**WEST SUSSEX COUNTY COUNCIL
STRATEGIC PLANNING CONSULTATION**

DATE: 19th May 2015

SUBJECT: LU/114/15/RES - Approval of reserved matters following outline permission LU/47/11 for layout, appearance and landscaping of access road.

LOCATION: Land north of Toddington Lane, east of southern section of proposed by-pass and west of parcels B3 and B5, Littlehampton BN17 7PP.

Drawing No.	CV8140927/600-1	Rev	P2
-------------	-----------------	-----	----

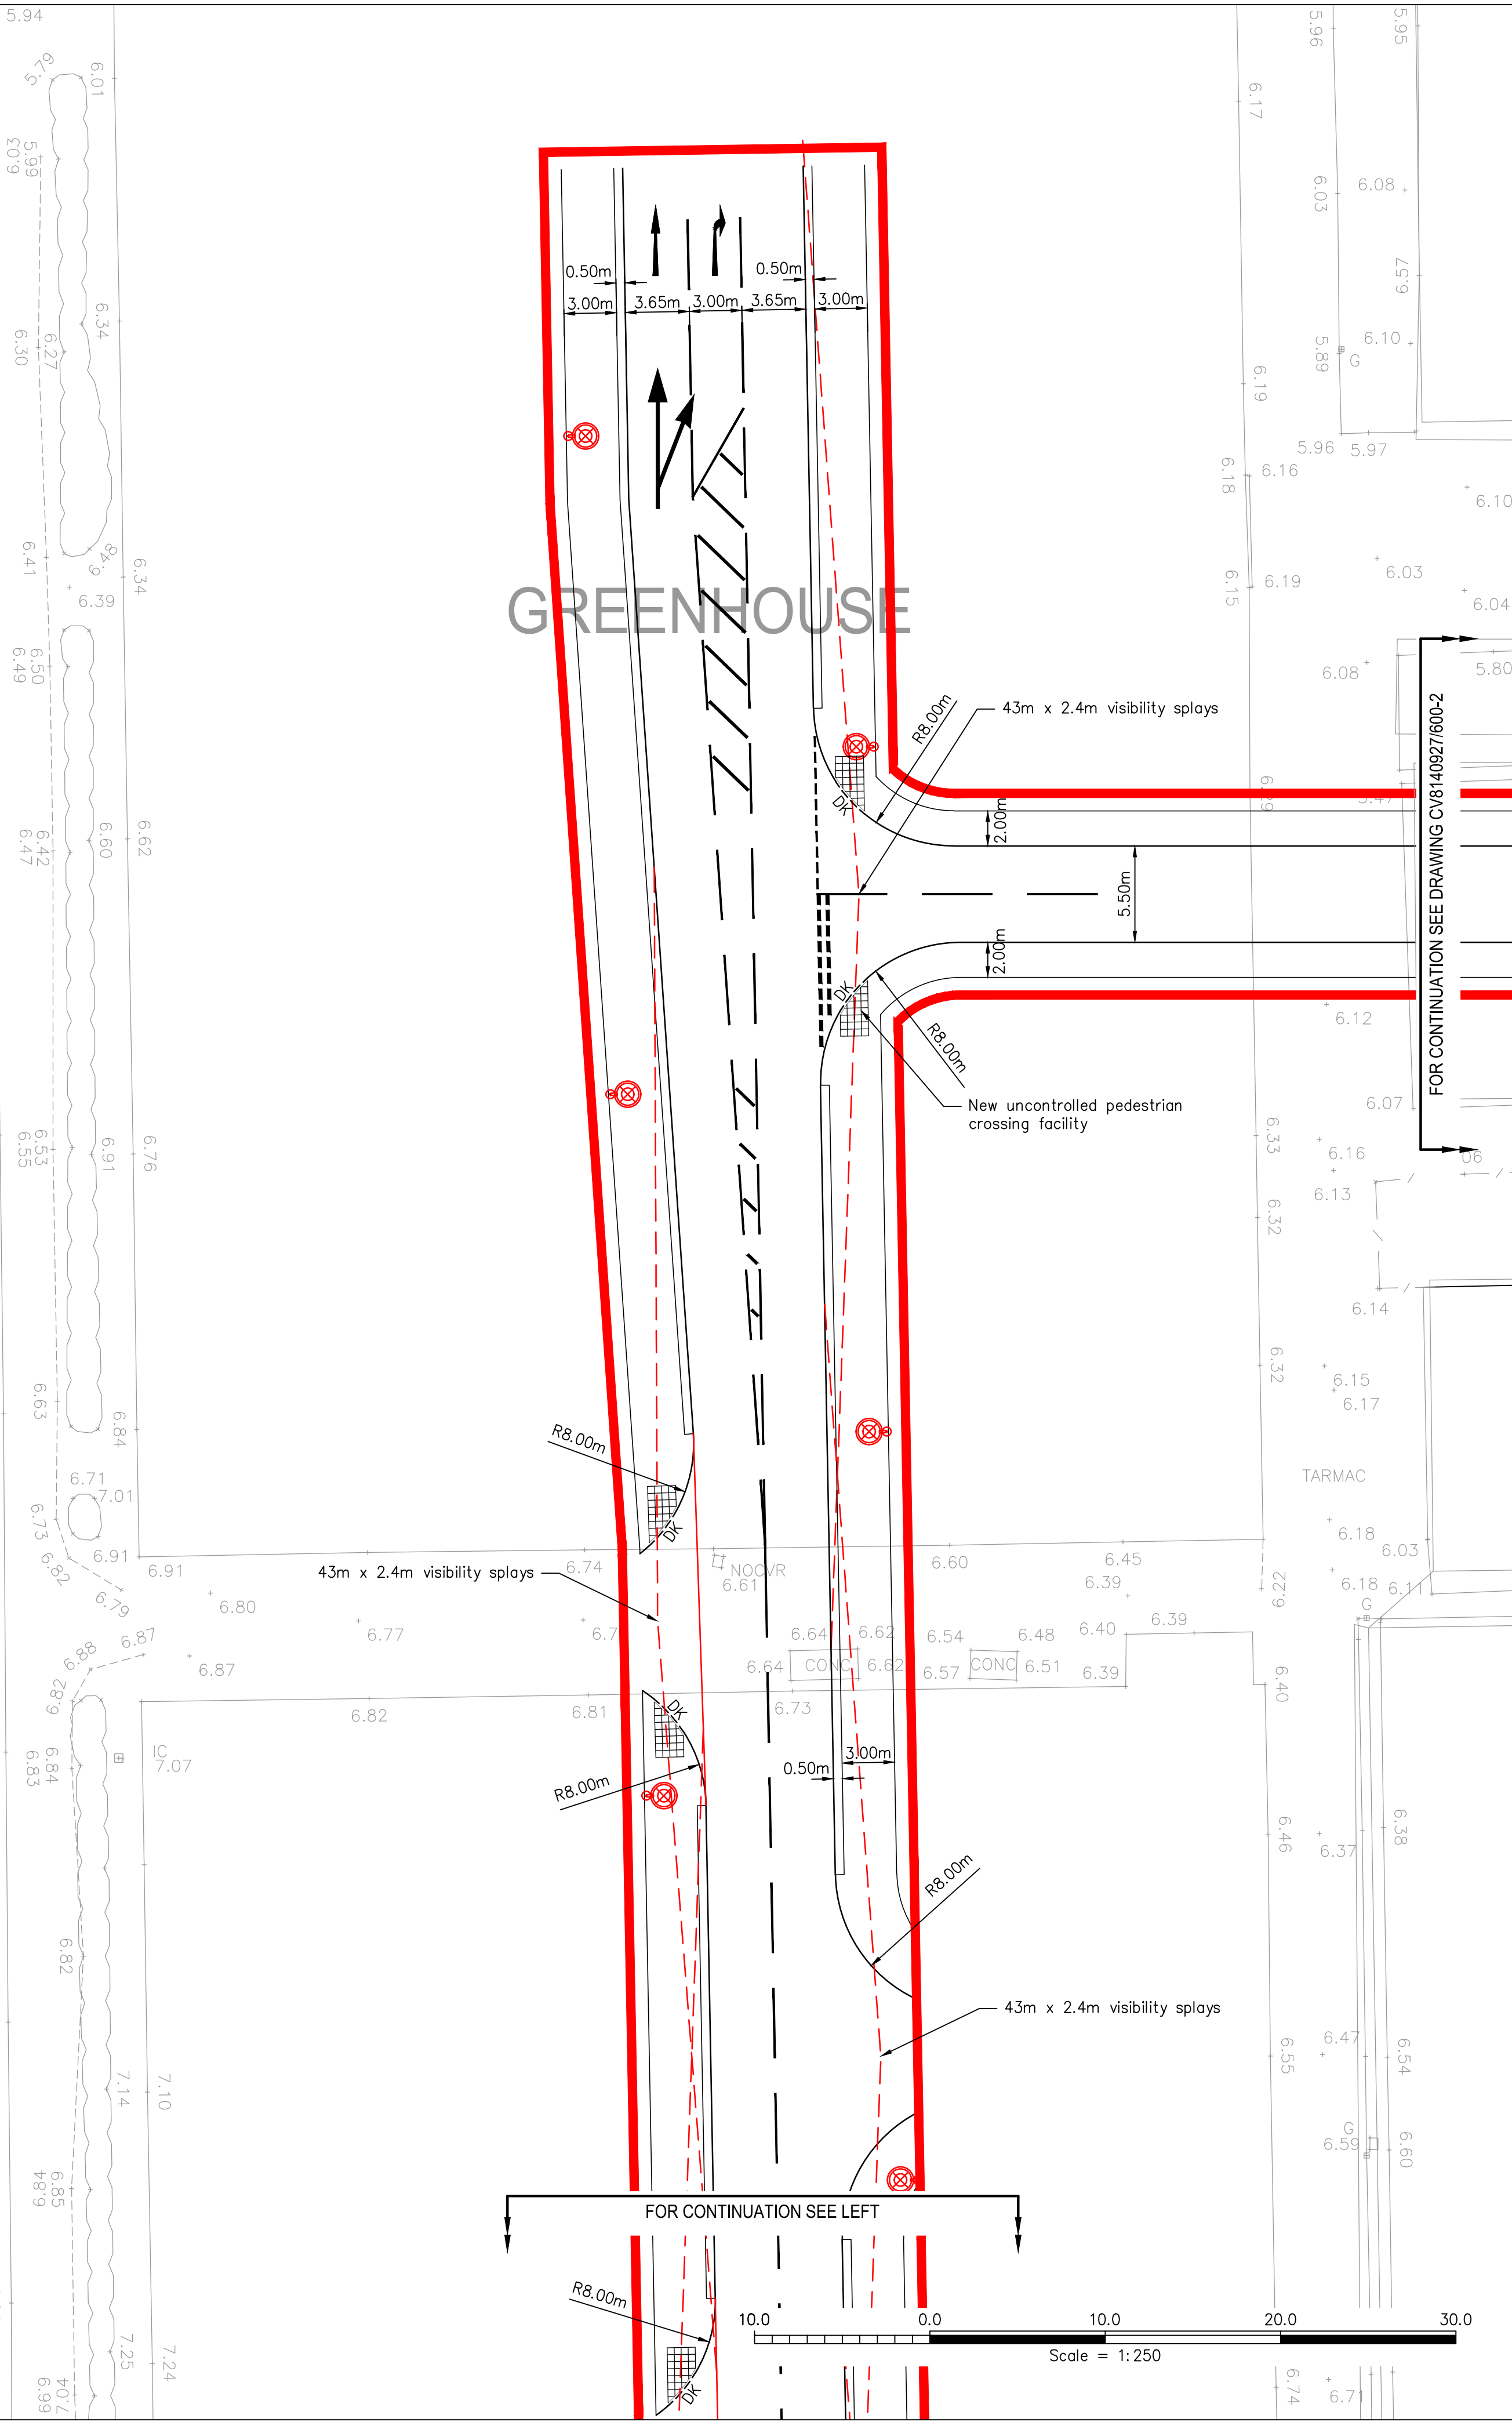
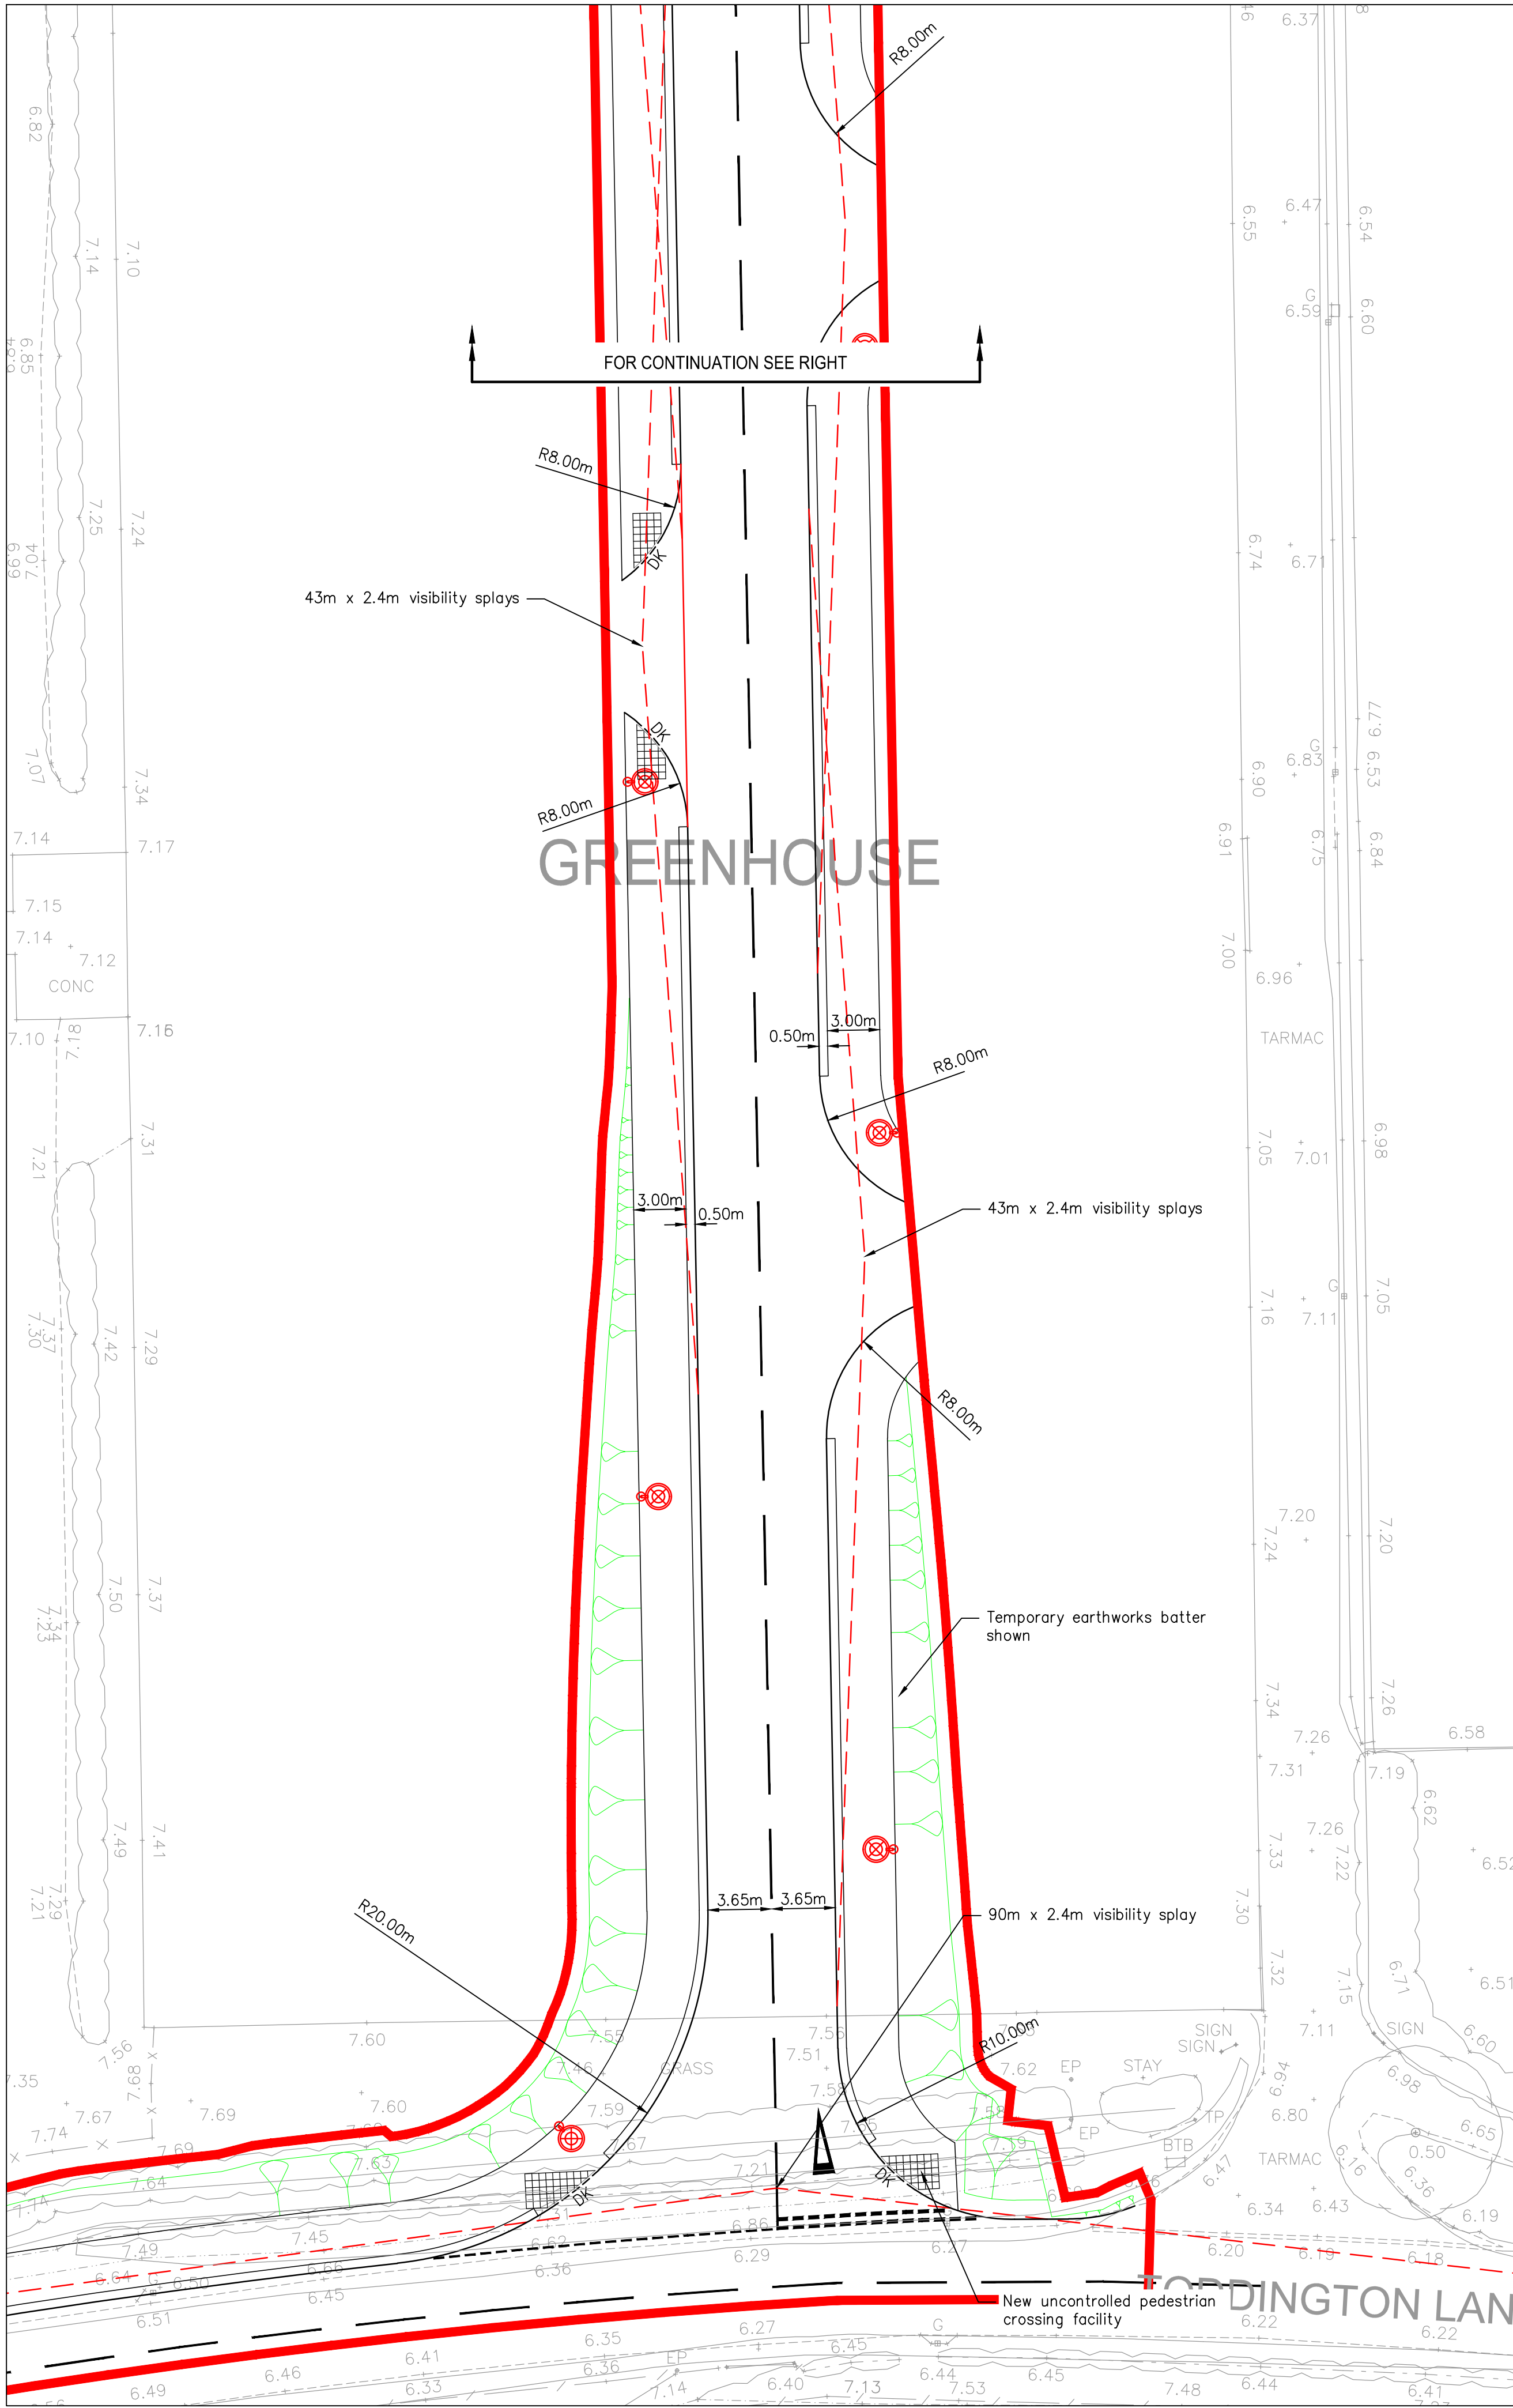
1. In accordance with WSCC policy, a Stage 1 Road Safety Audit (and Designer's Response) is required for all sections of access roads proposed to be used for bus routes and where they provide access to schools and community facilities. As the road now incorporates a right hand turning lane (shown at the northern end of the access road), this (alongside the full extent of road edged in red forming part of the application) should also be considered in its entirety (to include that further north and outside of the red edging) in the Safety Audit. Please provide.

2. A formal Design Check of the entire right hand turning facility should be provided.
3. Bellmouth radius, west side of junction with Toddington Lane – Bellmouth radius is shown at 20m. This has the potential to lead to high entry speeds for vehicles travelling from Toddington Lane turning left (north) into new road. Applicant to explain why this is shown

as it is. If designed to be temporary (for construction purposes?) then applicant to state when bellmouth will be made smaller when no longer required (including likely timing). If acceptable to the Highway Authority, provision for future amendments/alterations – and what those are – to be tied-into S38/S278 Agreement.

4. Please provide the full extent of visibility splays at all junctions (including forward visibility splays – commensurate to pedestrians and, where they will be present, cyclists). A 4.5m 'x' distance should be shown at the junction of the north-south road with Toddington Lane.

5. The footway on the eastern side of the main north-south access road (southern end) should be extended eastwards and tactile paving provided to correspond with a crossing point on the south side of Toddington Lane. Pedestrian visibility should also be shown at this point.
